Application No: EP/142/21/HH
Site Address: 38 Vermont Drive East Preston BN16 1LG
Description of works: Conversion of roofspace to habitable use to include 2 x side dormers, Juliet balcony and conversion of roof from hip to gable end and single storey ground infill extension.

Thank you for your internet representation made on 6th December 2021 which has been recorded as an objection with the comments as follows:

ARW Design	DRAWING TITLE: PROPOSED ELEVATIONS PROJECT: PROPOSED LOFT CONVERSION WITH HIP TO GABLE END & DORMERS TO SIDE ELEVATIONS		LOCATION: 38, VERMONT DRIVE, EAST PRESTON CLIENT: C. NORTH		SCALE: AS NOTED @ paper size A3 DATE: OCT 2021		DRAWING NO: 6037/2
					DRAWN: ARW		
					REVISION:

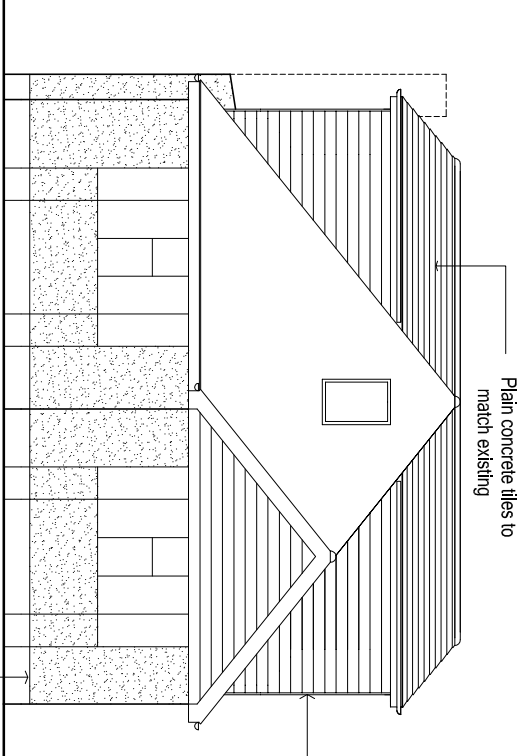
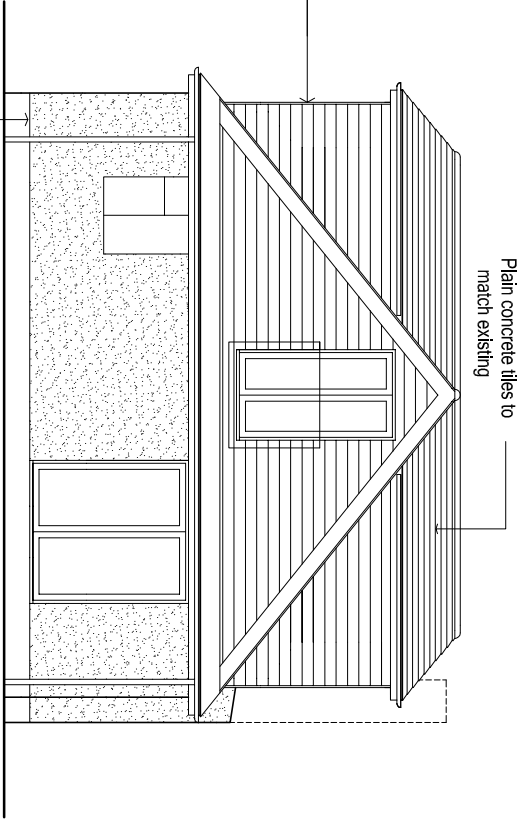
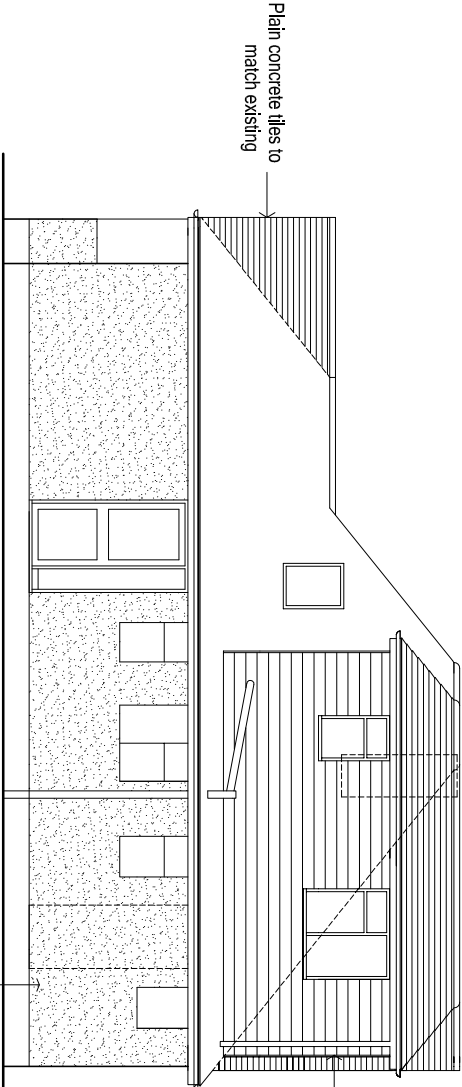
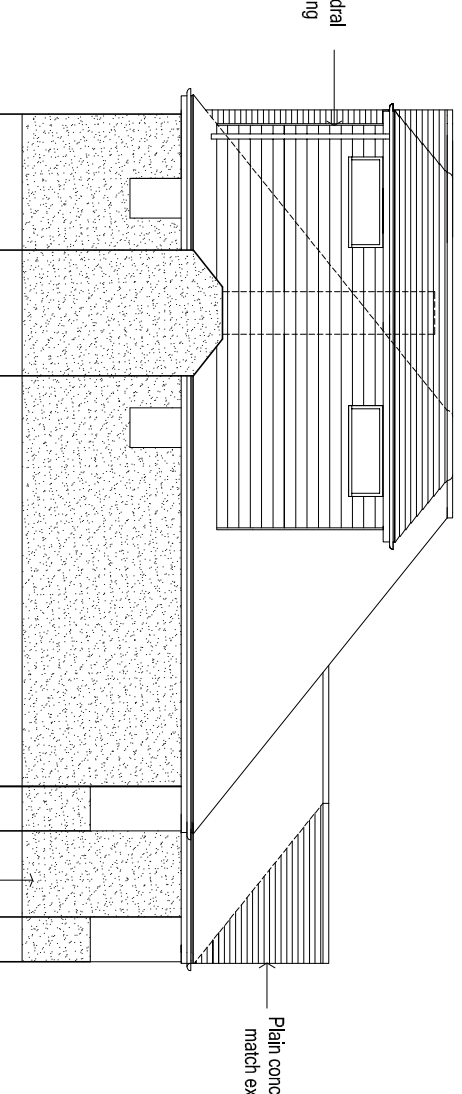
I live at 6 they Nookery and this house is behind my garden and one across to the right - meaning that any alteration to the roof space will mean that they can look into my garden Via the side dormer window and the double full length doors of then Juliet balcony. A window in this location would normally need to be obscured glass I am assuming but how could that happen with double opening doors? hence I strongly object to the plans as they are
